February 27, 2024

RE: R+L Carriers Maintenance, 2350 Aztec Rd NE
Site Dimensional and Paving Plan

In response to your review email dated January 18, 2024, we offer the following responses, in ***bold and italics***, to the outstanding comments:

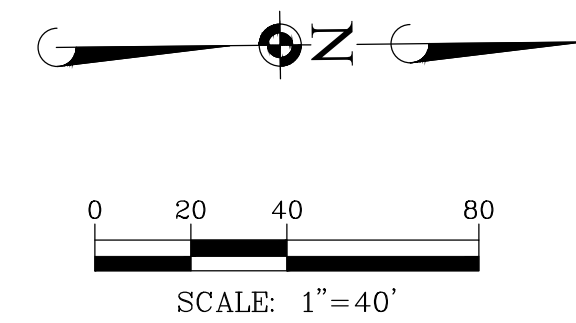
1. I received 2 sheets both labeled "EX". Usually a plan is titled "TCL" or "Site Plan".
Response: The Traffic Circulation Layout Sheet label has been updated to "TCL".

2. The sheets have no parking calculations or Keyed Notes.
Response: The Site data, parking calculations and key notes have been added to the Traffic Circulation Layout.

Response: Noted.
6. In addition to those comments, the site will need 3 bicycle parking spaces, which is basically 2 racks as two bikes can park at each rack. See images of requirements and a picture of a couple installed at a project.

8. An image of the accessible sign(s) to use.
Response: Accessible parking sign detail has been added, please refer to sheet 11 - Construction Details.
9. Add a note for the unused drivepad closure and that curb and gutter is to be constructed per City Standards.

11. On the original submittal, "Site Dimensional and Paving Plan.pdf" Note B should be revised to reflect the proper pavement marking. See attached image and requirements.

13. In the "Site Dimensional and Paving Notes"
 - a. Note 2. There are lots of types of barrier curb. Provide a detail.
Response: Curb details have been added, please refer to the sheet 11 - Construction Details.

- b. Note 6. Remove note and provide locations and dimensions.
Response: Note has been removed and locations and dimensions have been added to the plan.

- c. Note 7. See b above.
Response: Note has been removed and locations and dimensions have been added to the plan.
 - d. Note 8. Provide the details for proper construction. See attachments.

Response: The details has been added please refer to sheet 11 - Construction Details.
 - e. Note 10. Insufficient to specify federal and state standards. It is common to have the sidewalk flush with the adjacent paving at the accessible access aisle then ramp up to the sidewalk grade. An arrow drawn on the sidewalk works or you can use a detail.

Response: The bicycle parking spaces have been added, please refer to the updated sheet 6 - Site Dimensional and Paving Plan and Traffic Circulation Layout.

Response: A note has been added, please refer to the revised sheet 5 - Site Dimensional and Paving Plan and Traffic Circulation Layout and City Standard details have been added to sheet 11 - Construction Details.

Response: Note B has been revised.
12. Provide a keyed note for the items to be constructed at the truck entrance/exit.
Response: Please refer to the truck entrance/exit detail provided on sheet 10 - Construction Details for the items to be constructed at the entrance.

Response: The accessible route arrows have been on the sidewalk.
 - f. Note 11. Calling 811 is the correct phone number. Remove 505-254-7310.
Response: The number has been removed.
